CITY OF PORTLAND BUILDING PERMIT

Job ID: 2012-04-3684-ALTCOMM

has permission to Build a 2'5"(at 4'slope ht) x 20' shed dormer to increase headroom in existng 3rd floor apartment living room provided that the person or persons, firm or corporation accepting this permit shall comply with all of the provisions of the Statues of Maine and of the Ordinances of the City of Portland regulating the construction, maintenance and use of the buildings and structures, and of the application on file in the department.

A-21 ELEVATIONS

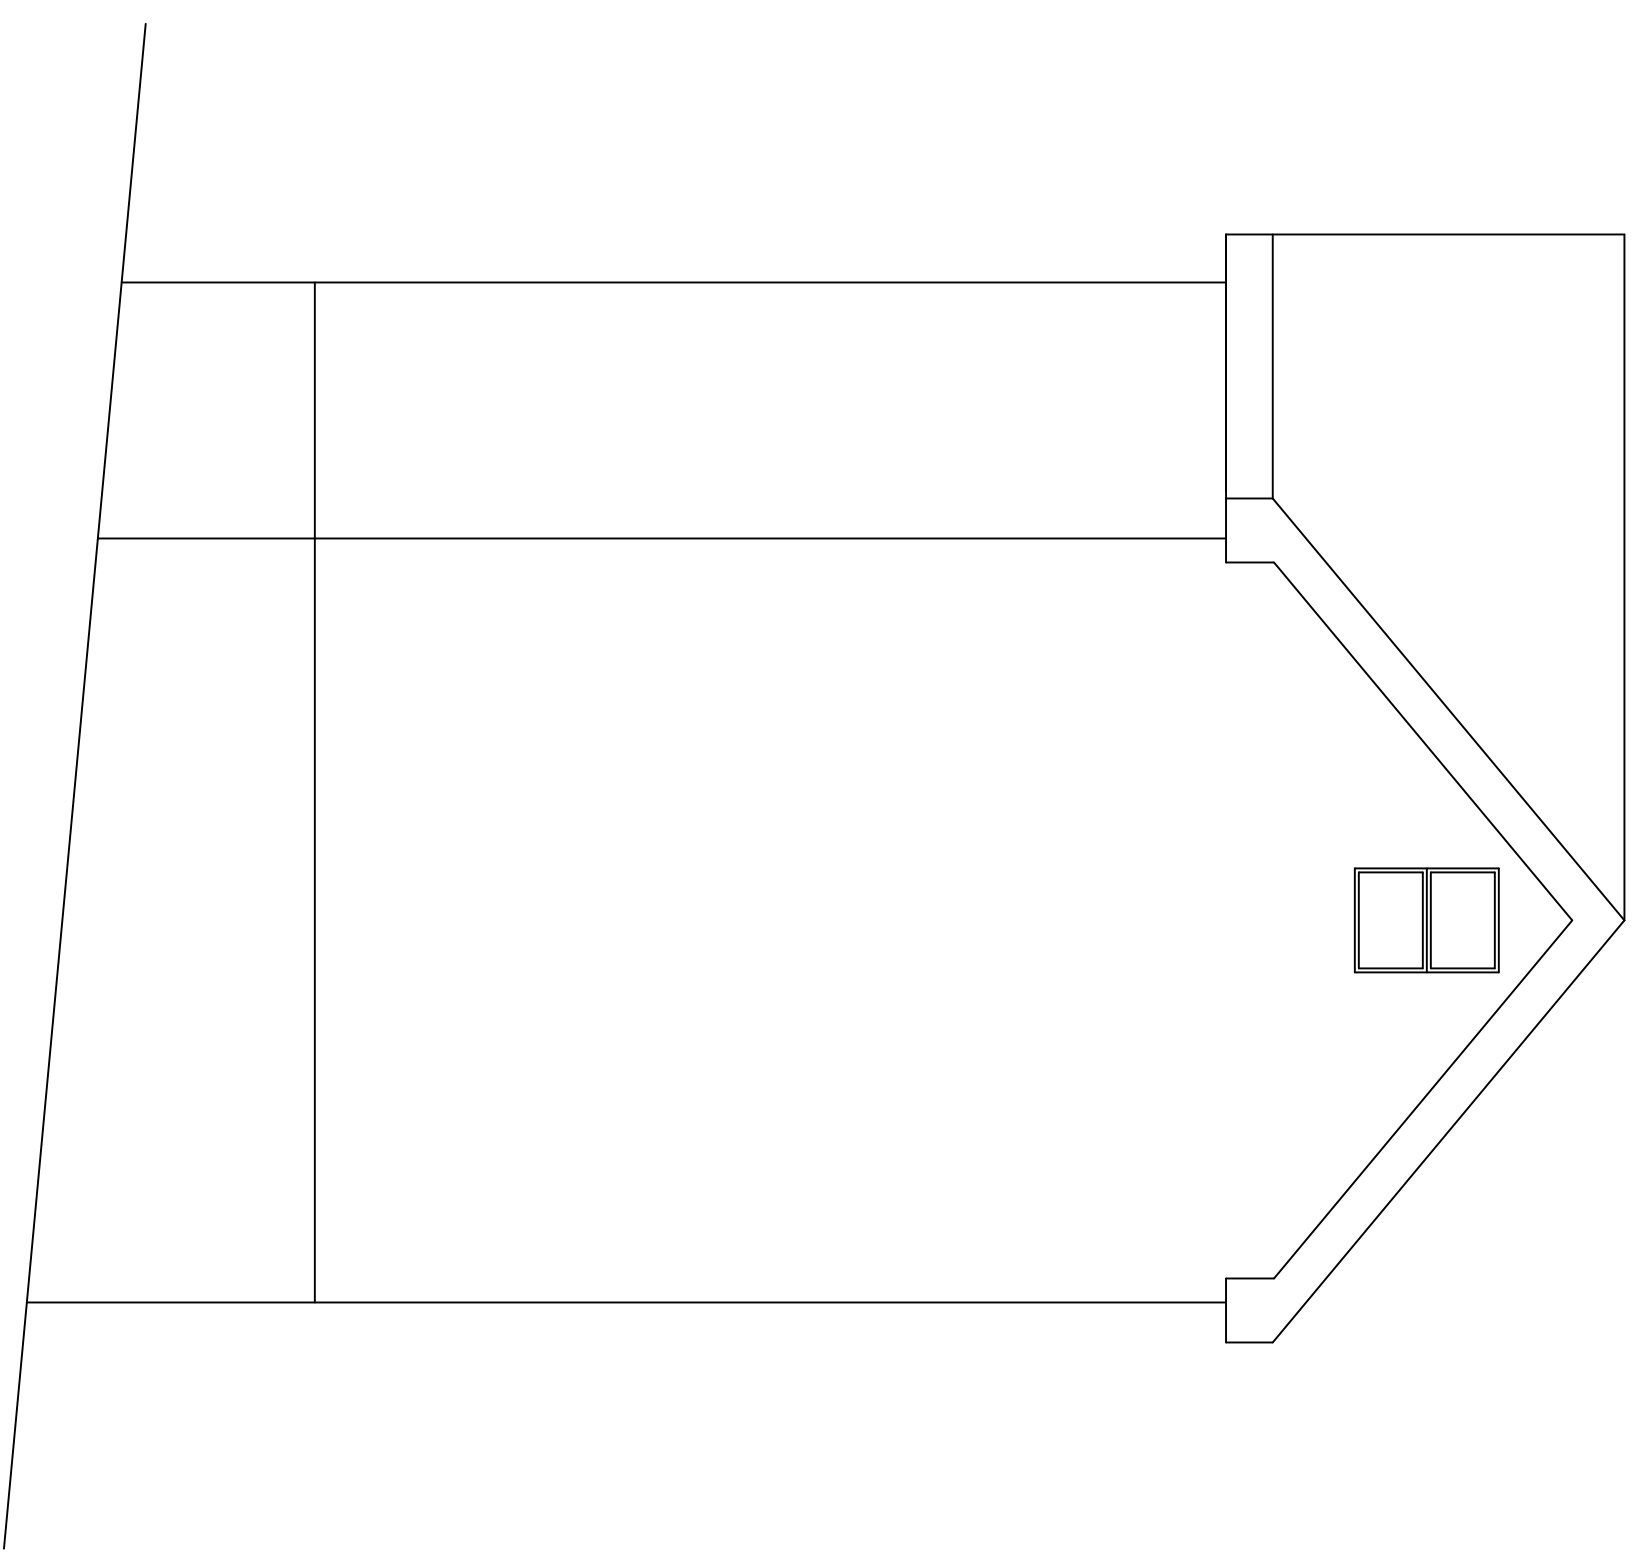
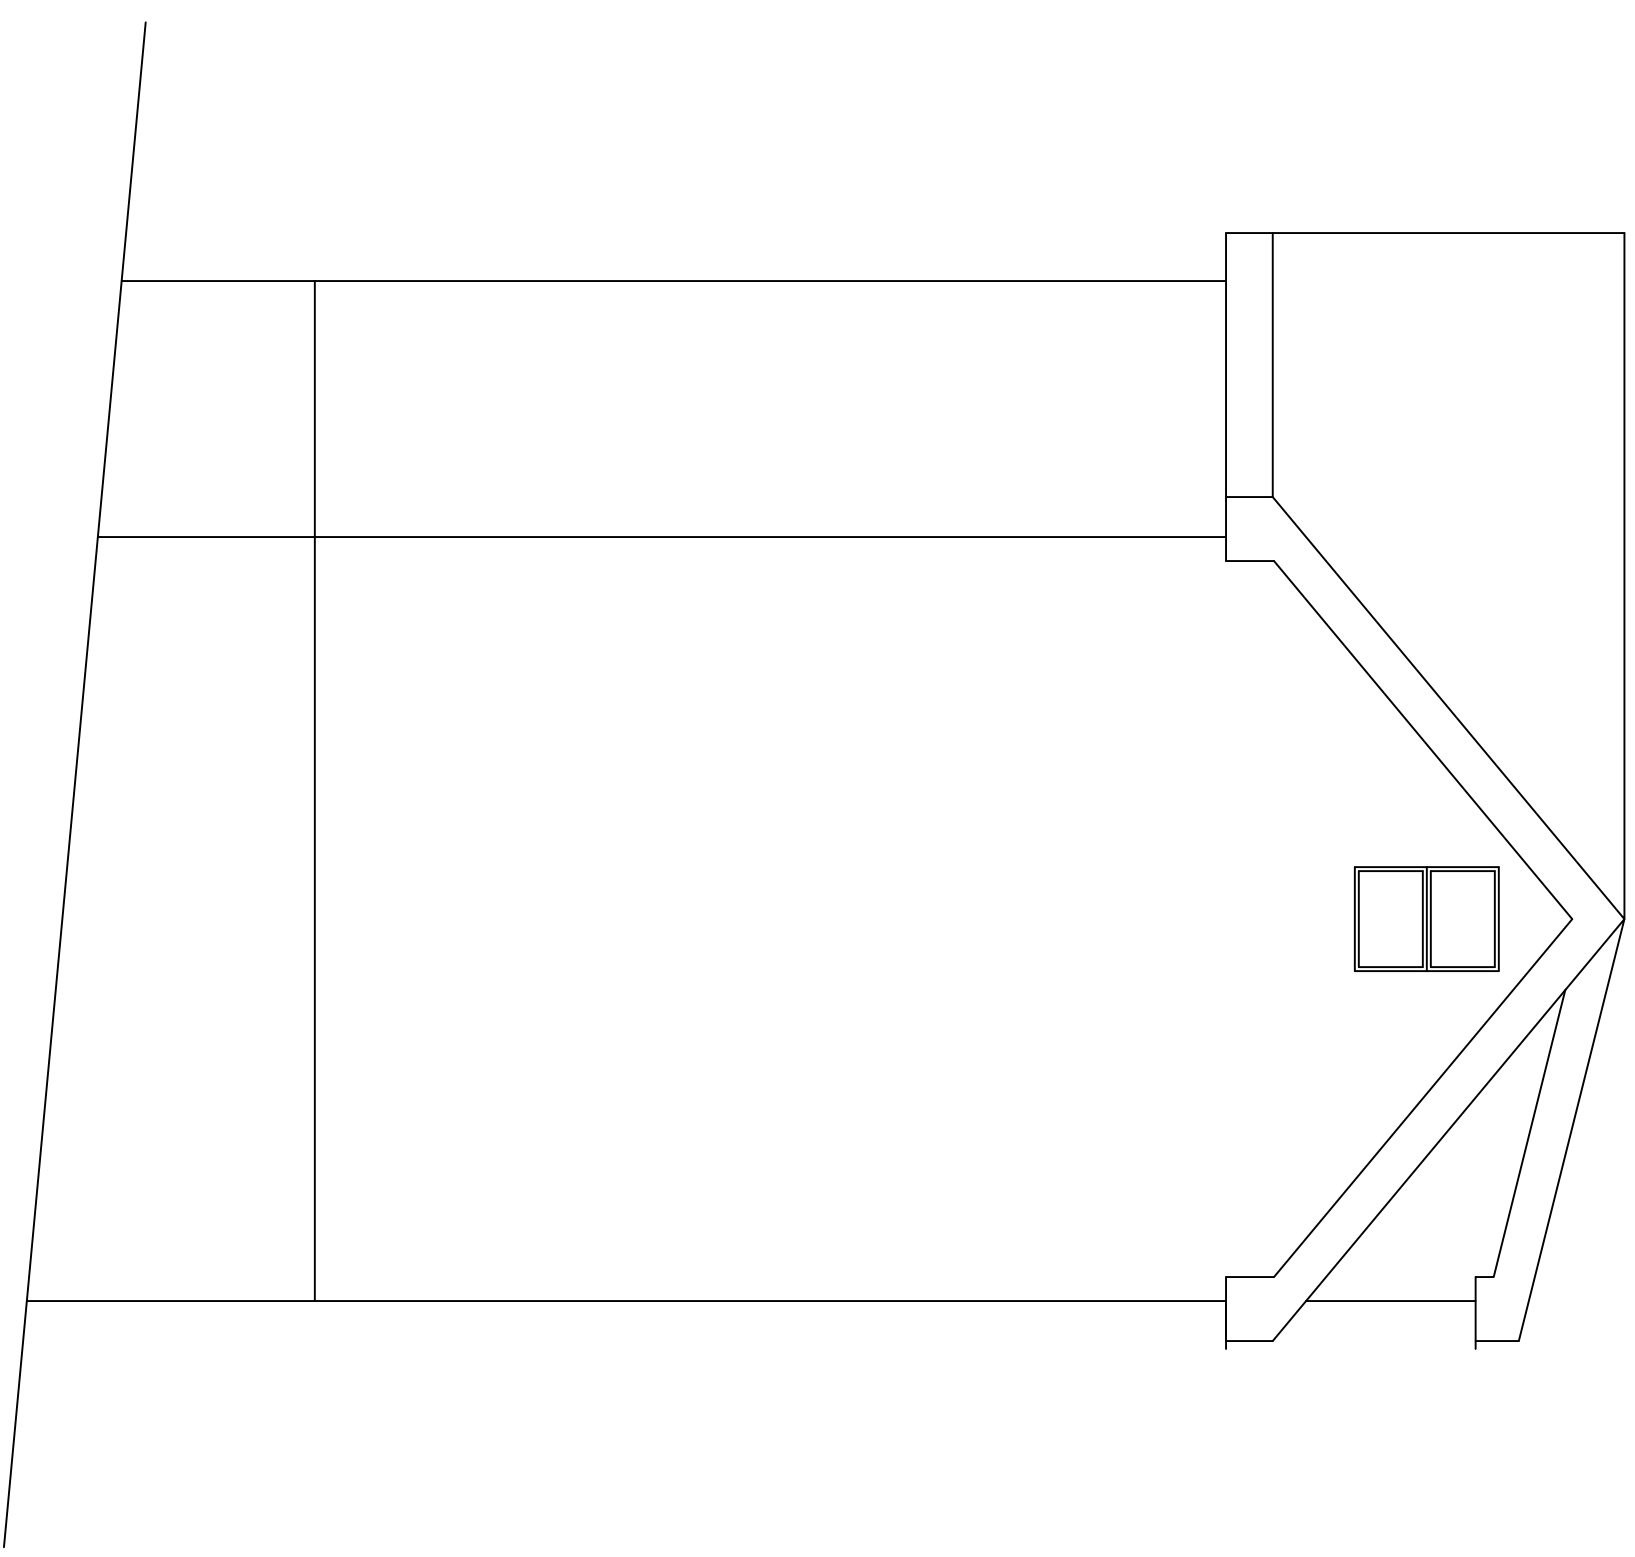
1. Application approval based upon information provided by applicant. Any deviation from approved plans requires separate review and approval prior to work.
2. Permit approved based on the plans submitted and reviewed w/owner/ contractor, with additional information as agreed on and as noted on plans, including the roof pitch to be a minimum of 2:12.

FRAMING CROSS SECTION

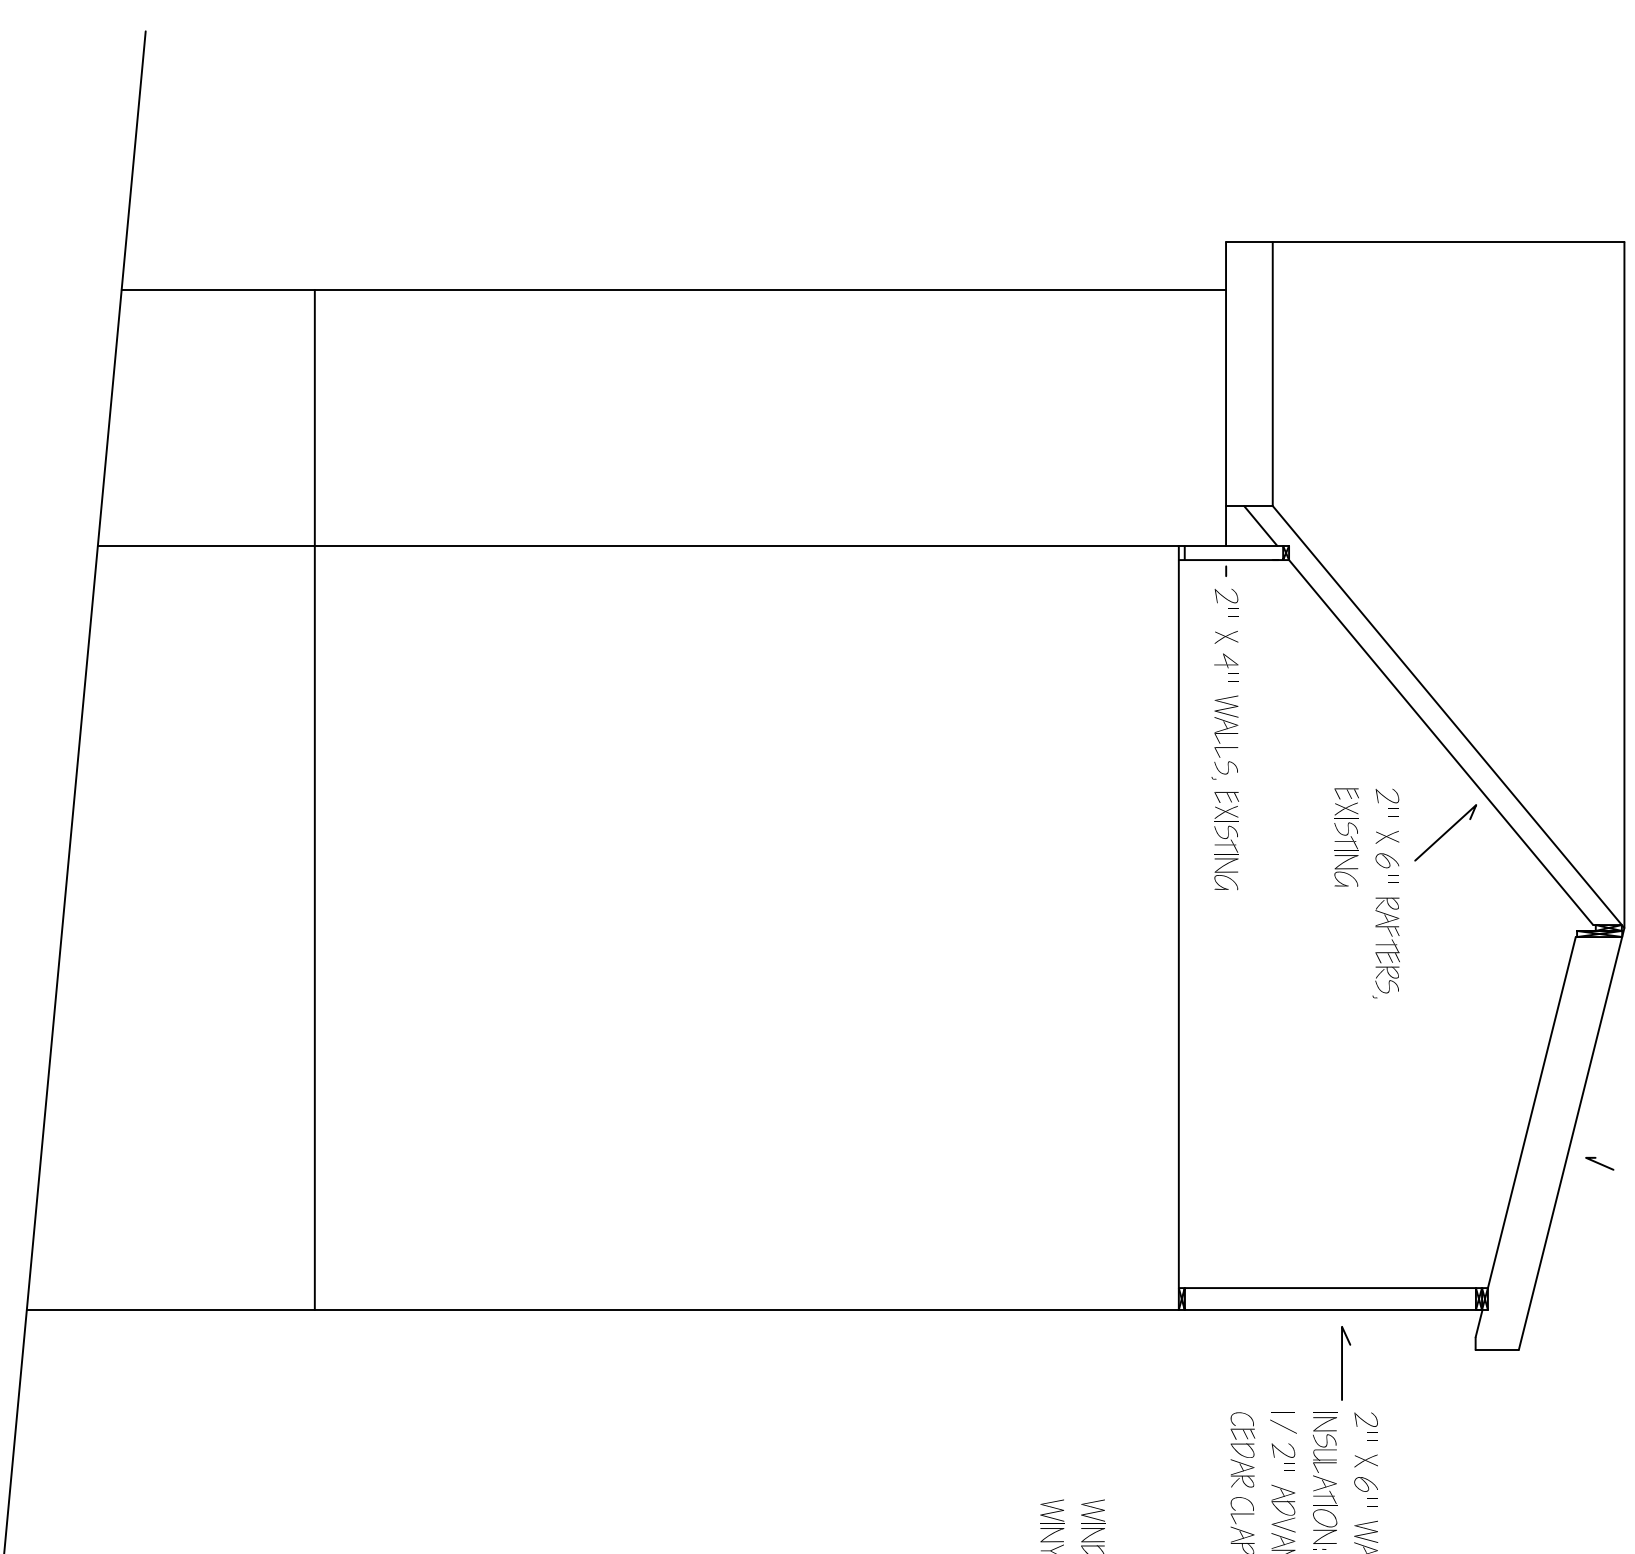
5-9 & 5-10 Advice of Ben C. & Joe D. about tie in of former to main Roof & Structural integrity of Ridge board. Require a Third party Engineers review. JMB

7. Upon exposing the existing rafter/valley framing at the ridge, any deficiencies shall be addressed. Connections and ties shall be installed from the existing rafter framing to the new shed dormer framing and ridge. This shall be inspected prior to close in.

5/14/12 Rcv'd call from Chris Ray (engineer) on site - he was assessing the framing - New is acceptable. While a beam at the ridge is advised, using simpson rafter strap connectors from the new to old roof is acceptable. Ben C. will call for inspection. JMB
